**ADDENDUM TO SECTION 75W MODIFICATION APPLICATION TO MP10_0230
WOOLLOOWARE BAY TOWN CENTRE**

We wish to seek an addendum to the Section 75W Modification Application submitted for MP10_0230. This addendum relates to the deletion of the retail tenancy on the corner of Captain Cook Drive and Woollooware Road North. An amended Level 1 plan illustrating the deletion of this tenancy is provided at **Attachment A**.

LEVEL 1 PLAN

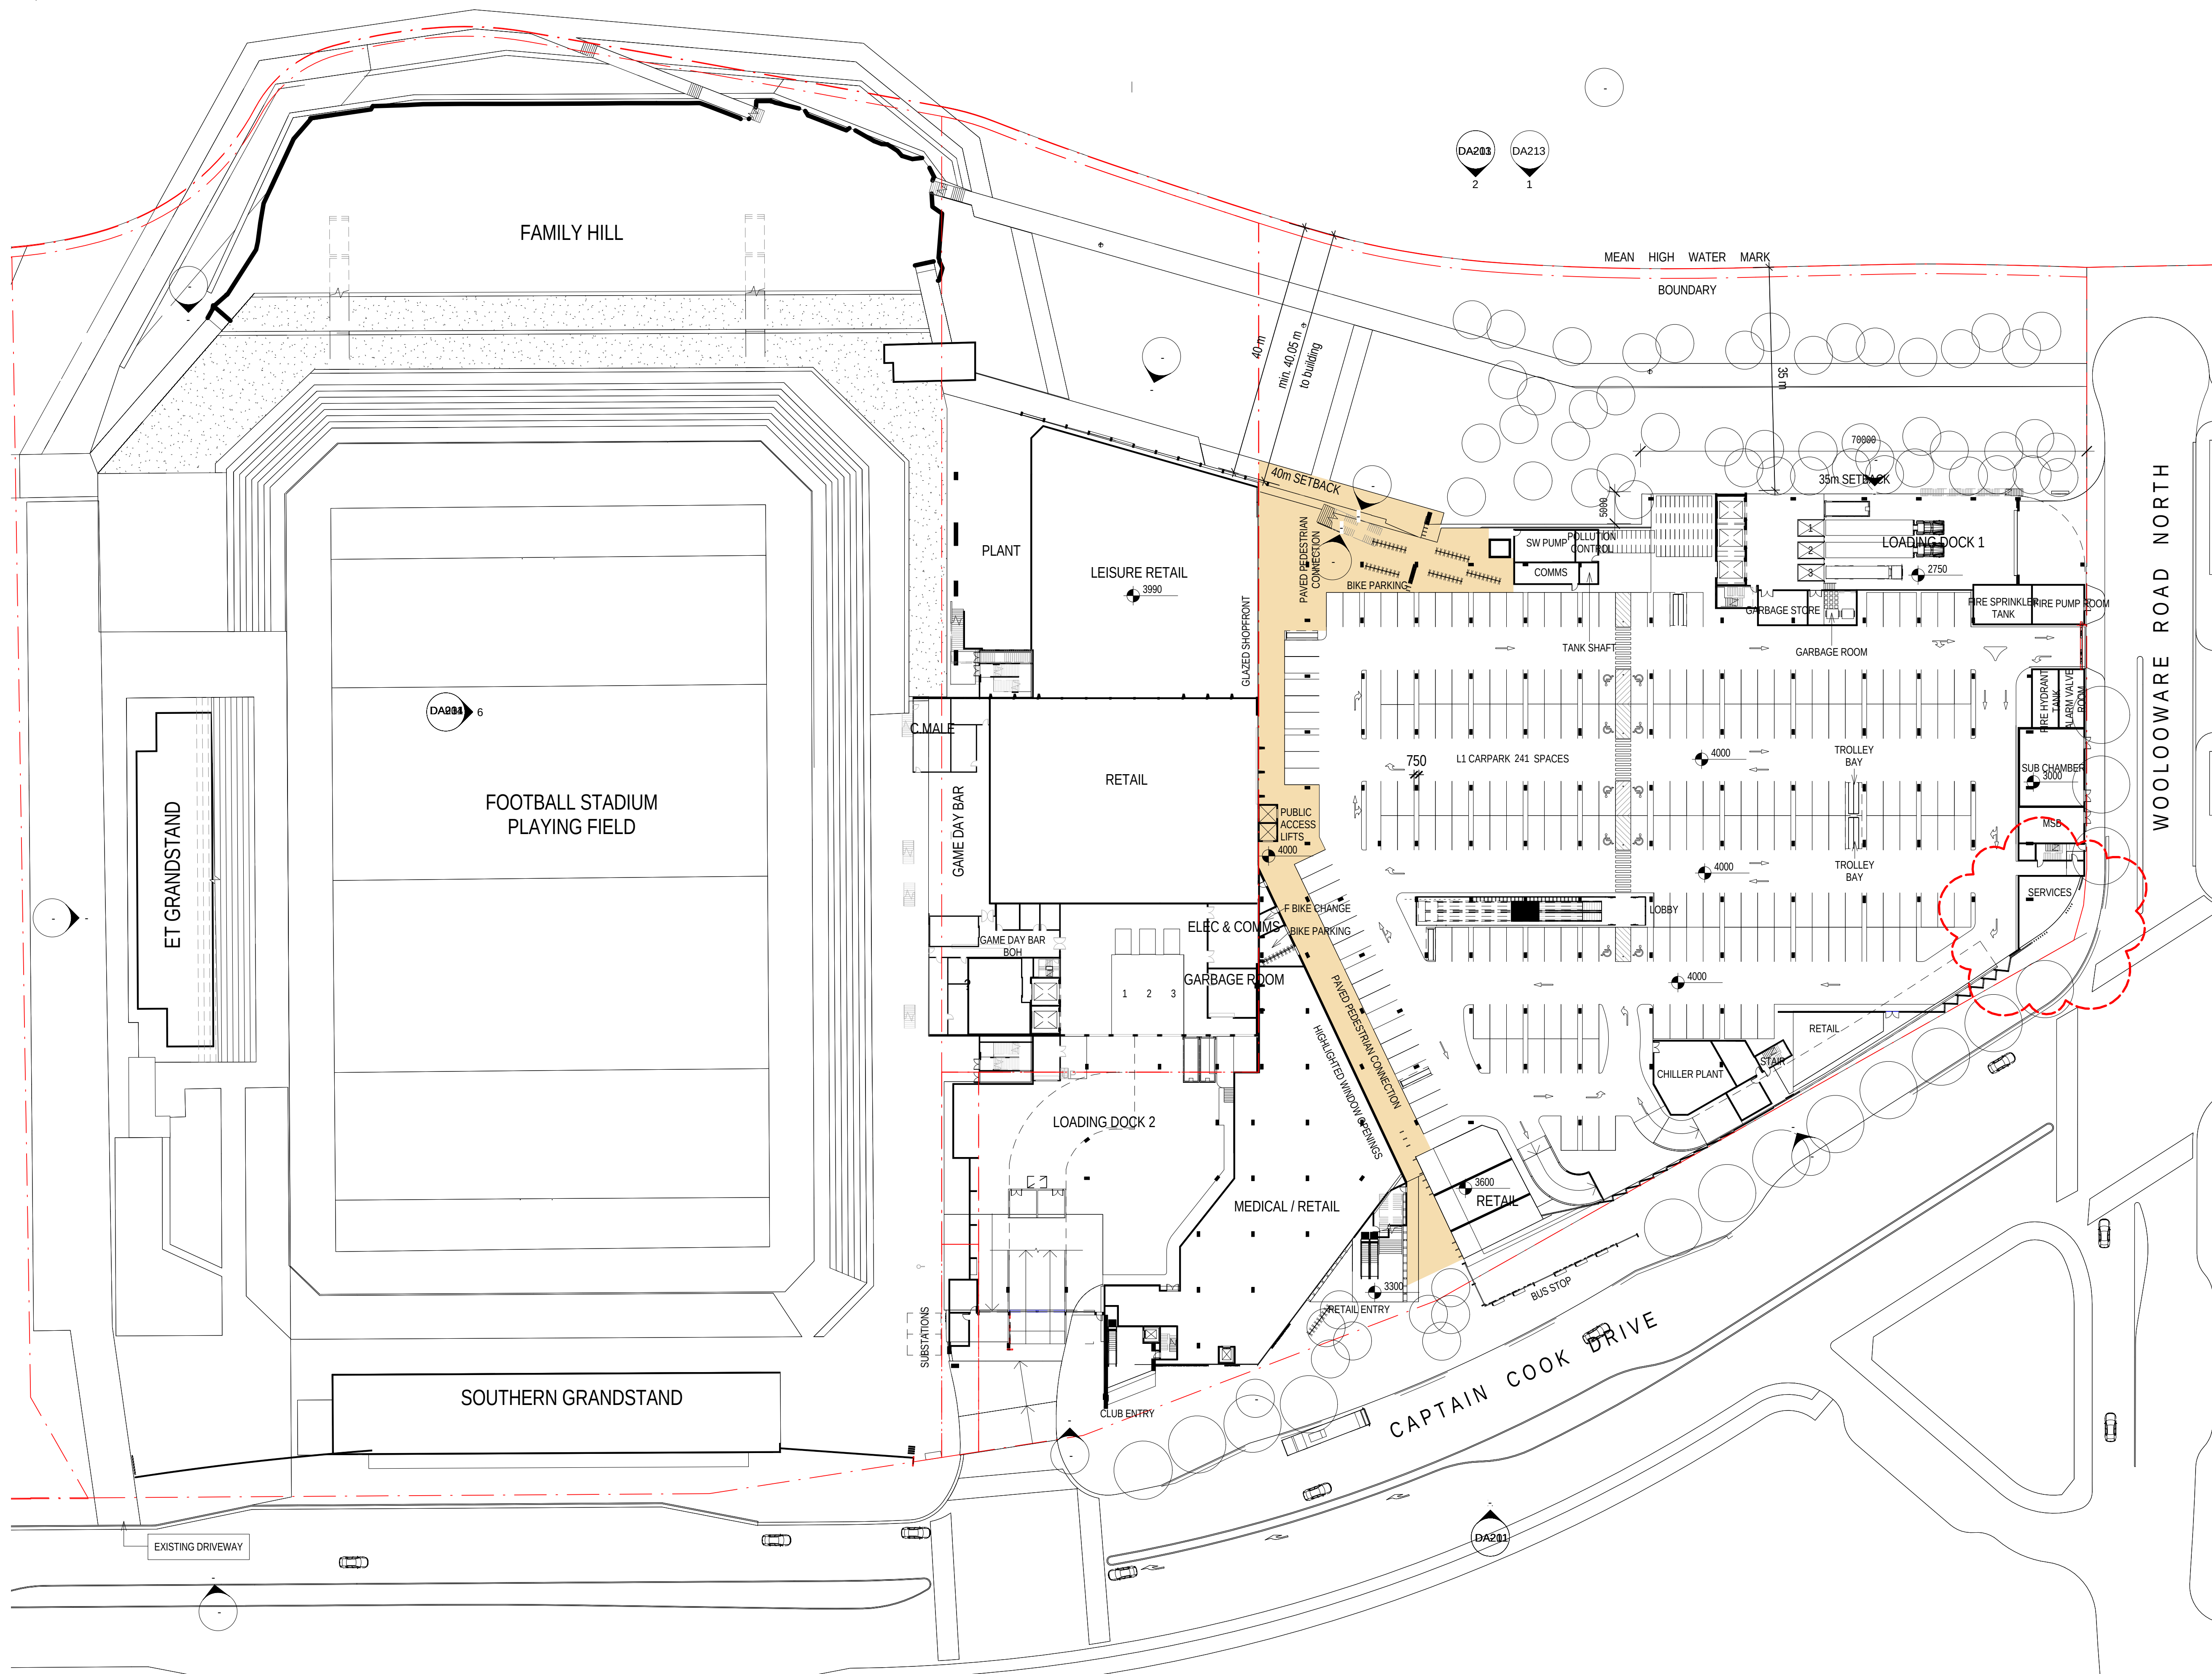
The retail outlet on Level 1 on the corner of Captain Cook Drive and Woollooware Road North is to be deleted.

This condition was imposed by the Planning Assessment Commission (PAC) at the time of the determination of the project. Following the deletion of this tenancy, a recalculation of the Gross Floor Area (GFA) of the proposal has been carried out (refer to **Attachment B**). The total GFA of the proposal is 26,473.5m², below the maximum GFA of 26,495m² specified for the Retail/Club precinct under the Concept Plan. This constitutes a minor increase of 0.5m² to the originally approved project, necessitating an amended to Condition A1 of the approval, as shown below (deletions in ~~**bold italic strikethrough**~~ and additions in **bold italics**):
